DEVELOPMENT HEARING OFFICER

PR-2020-004171

PROJECT NAME:

FIERRO & COMPANY agent for WILLIAM E. GALBRETH LAND DEVELOPMENT CO. LLC requests the aforementioned action(s) for all or a portion of: TRACT N-7-A-1, BULK LAND PLAT OF TRACT N-7-A-1 TANOAN PROPERTIES zoned R-1D, located at 12300 SAN ANTONIO DR between LOWELL DR NE and TENNYSON ST NE containing approximately 6.653 acre(s). (E-22)

SHEET 2 OF 5

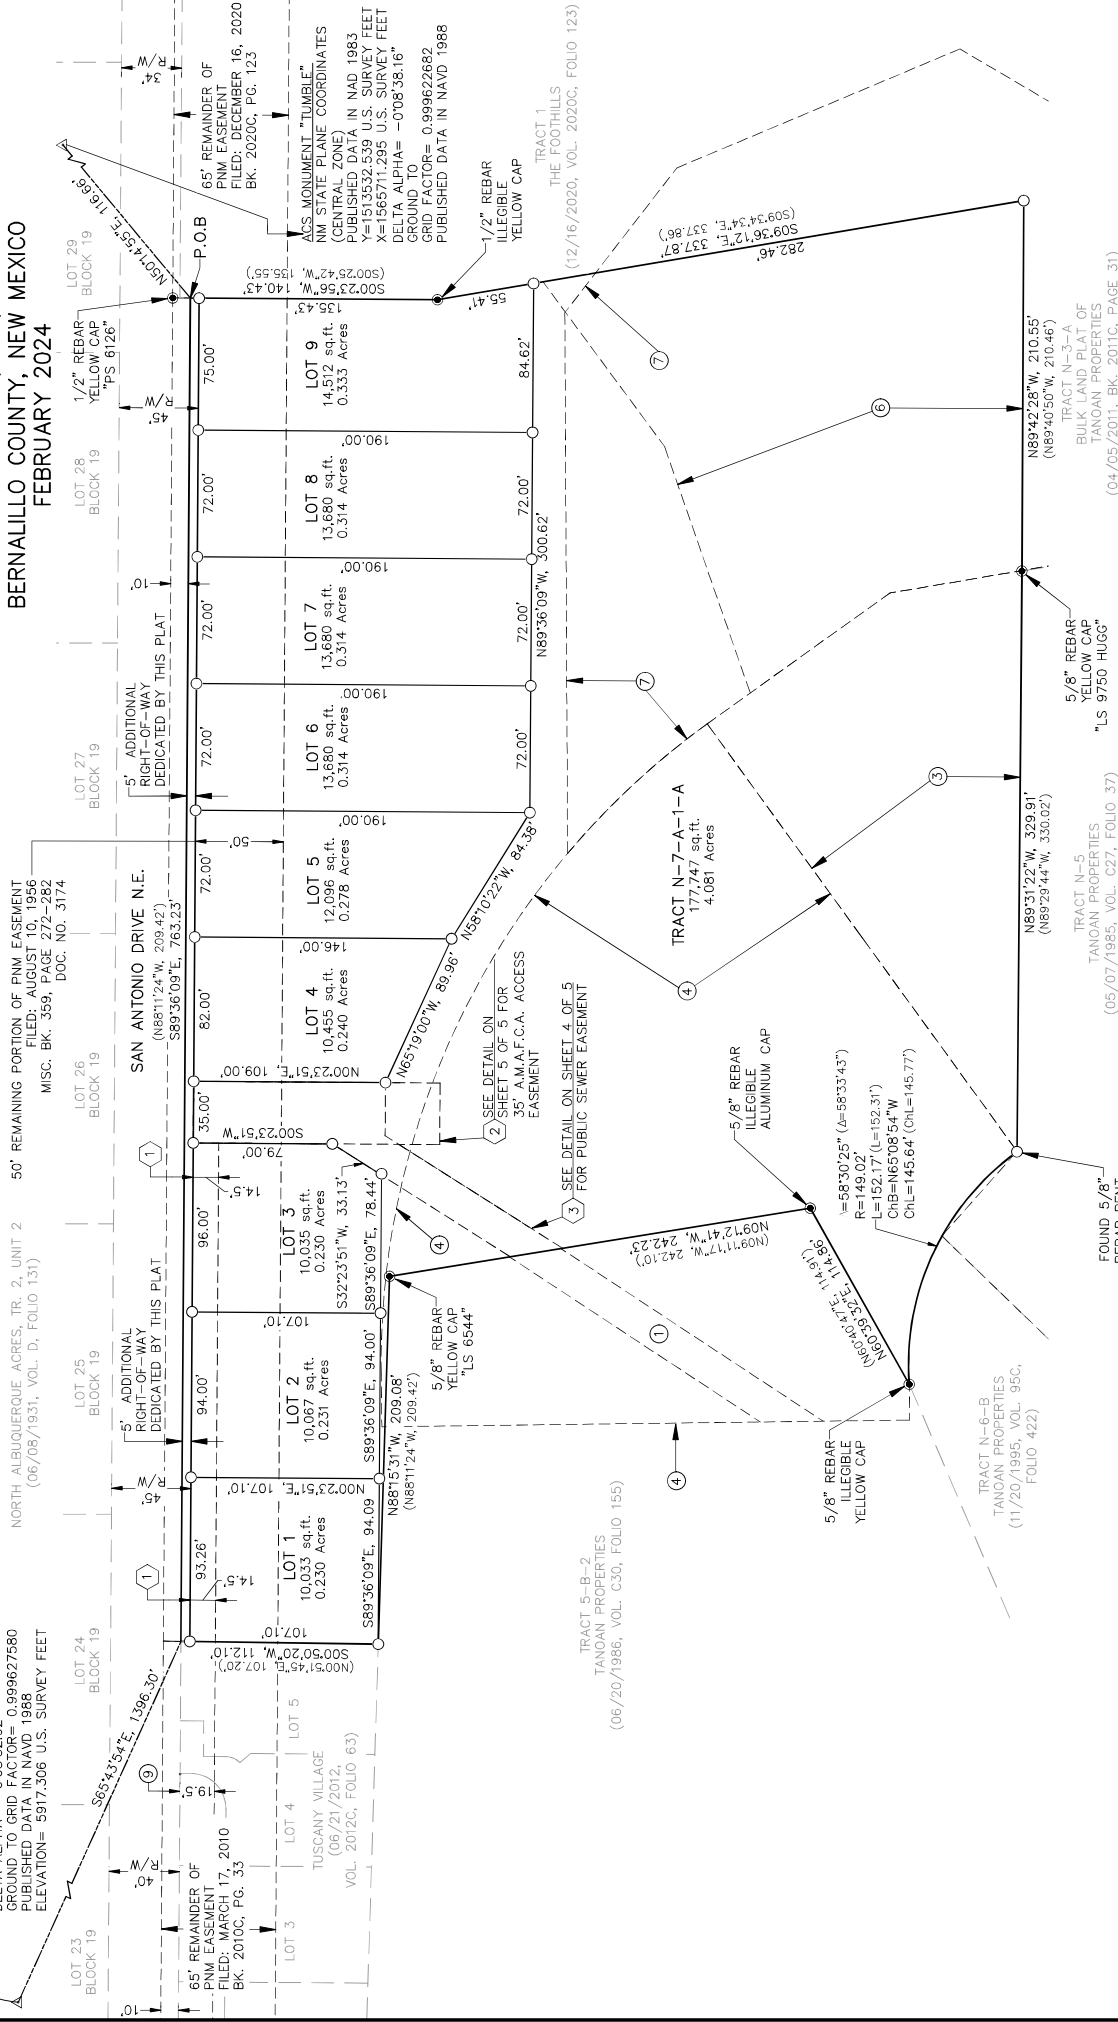
1. No objection
 - a. The sanitary sewer easement is being replaced by a new easement.
